From:
To: [DCAdmin](#)
Subject: Planning Application 2023/90718 Comments & Objections
Date: 08 June 2023 16:31:17

Re Planning Application 2023/90718

East Elevation

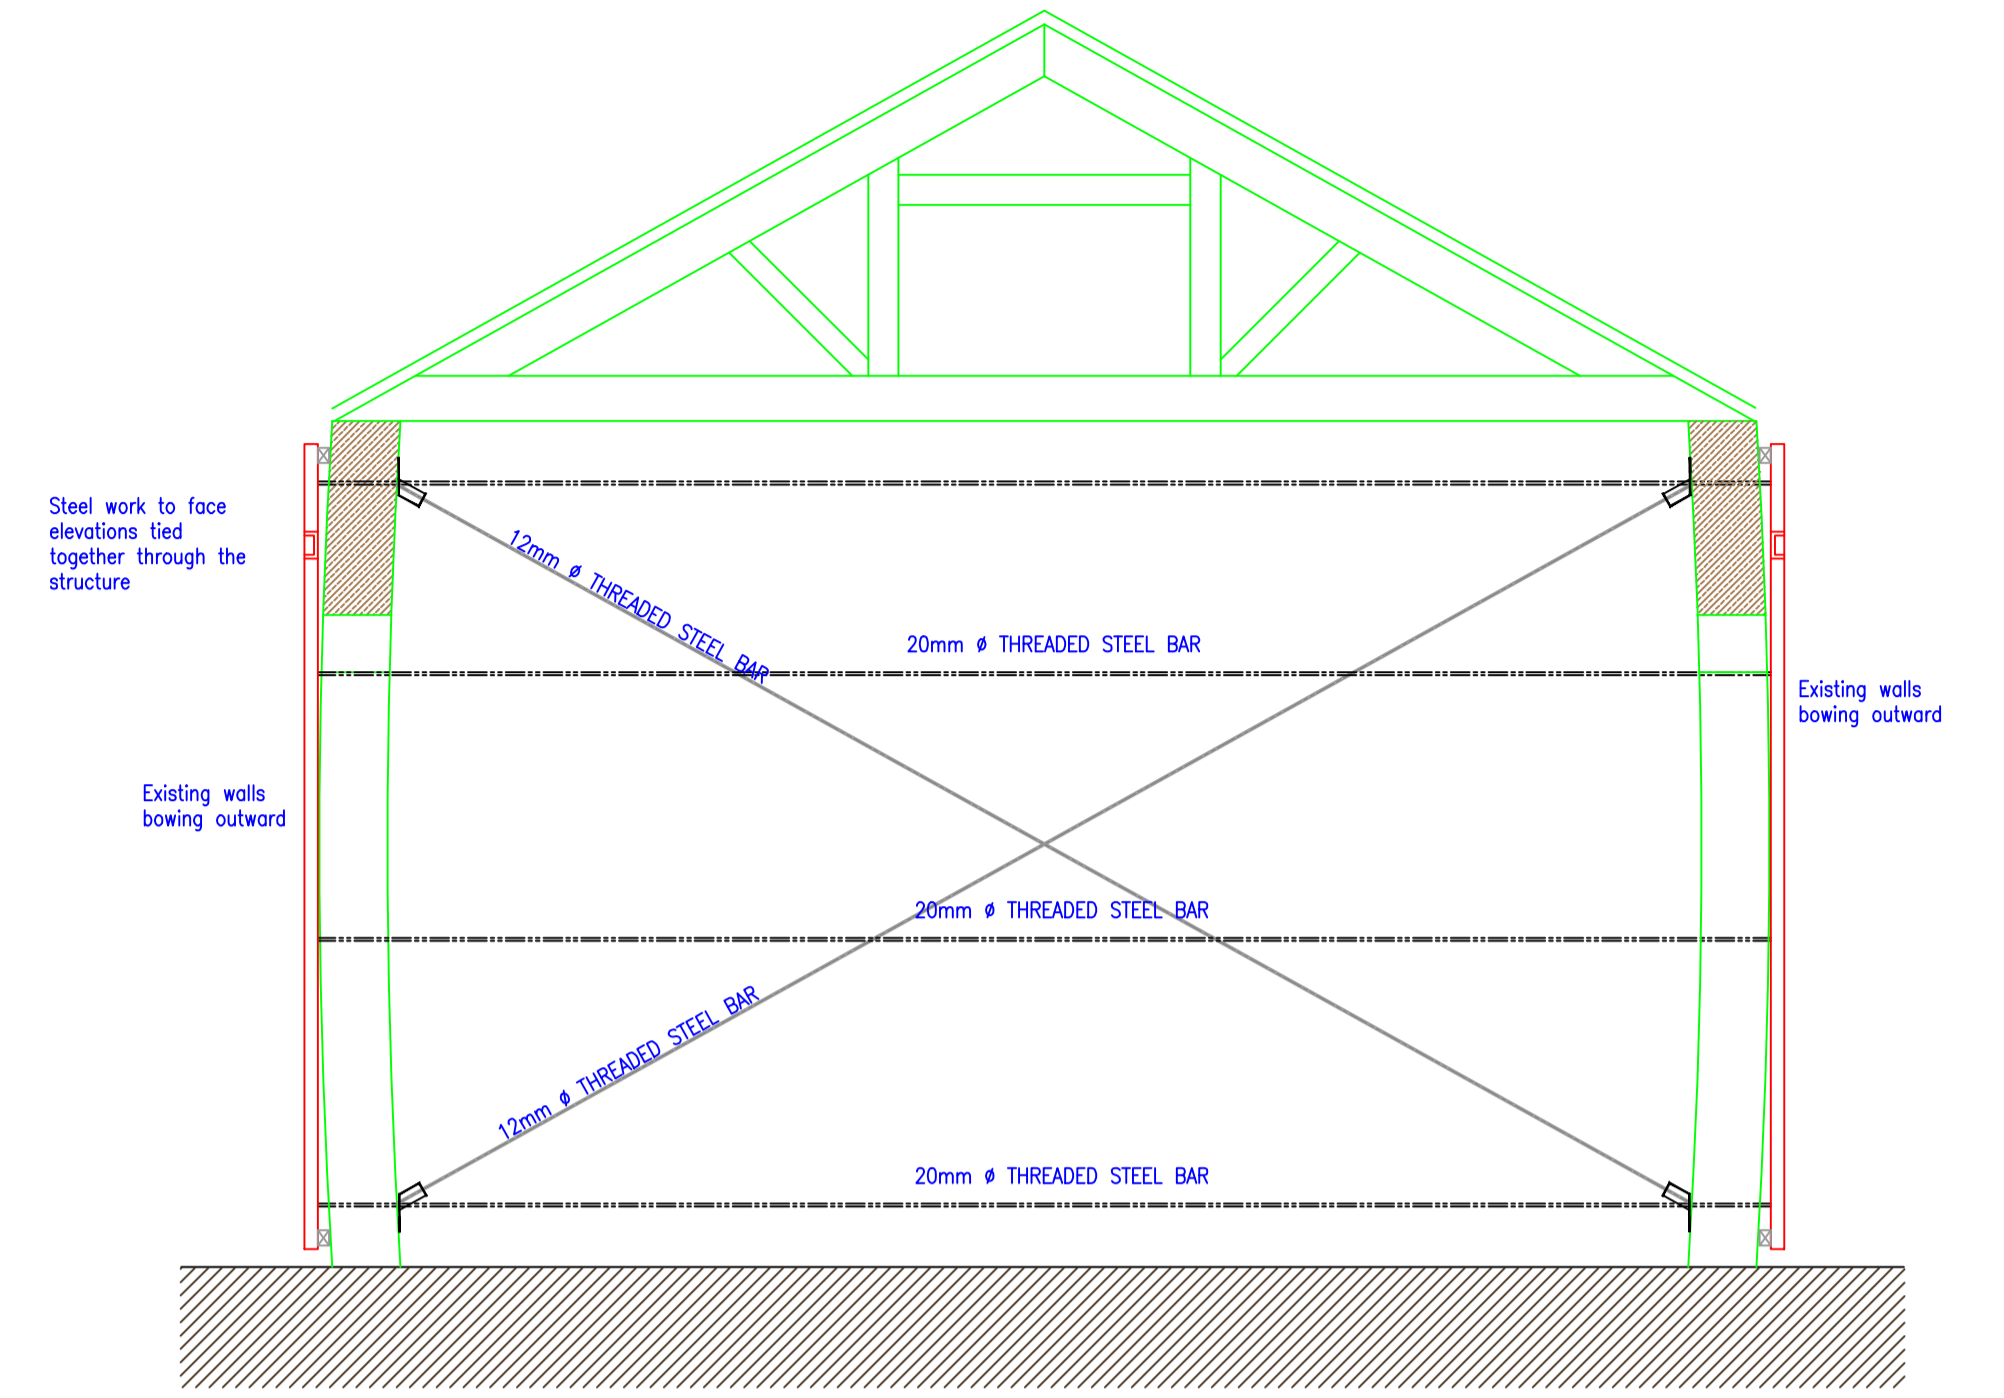
- a) An arched window on East (SHOULD read West) which will directly overlook my entire garden, back door & kitchen. This Elevation is also my boundary wall.
- b) An entrance door on North (SHOULD read South) opens directly across my drive entrance & within 10 feet/3 metres is looking into my lounge
These two apertures on a Grade 2 Listed Building have been blocked with stone infill since 1913 when No`s 4 - 32 were purchased by Huddersfield Council & ownership of the Barn was retained by (No 2) The Angel PH
In short, the entrance doors shown as present are both blocked one for over 100 years & the other for at least 12 years
There is no pavement on the North (SHOULD read South) elevation so both entrance doors lead directly onto narrow Vehicular Rights of Way
- c) Any windows/doors on the North (SHOULD read South) elevation will allow overlook
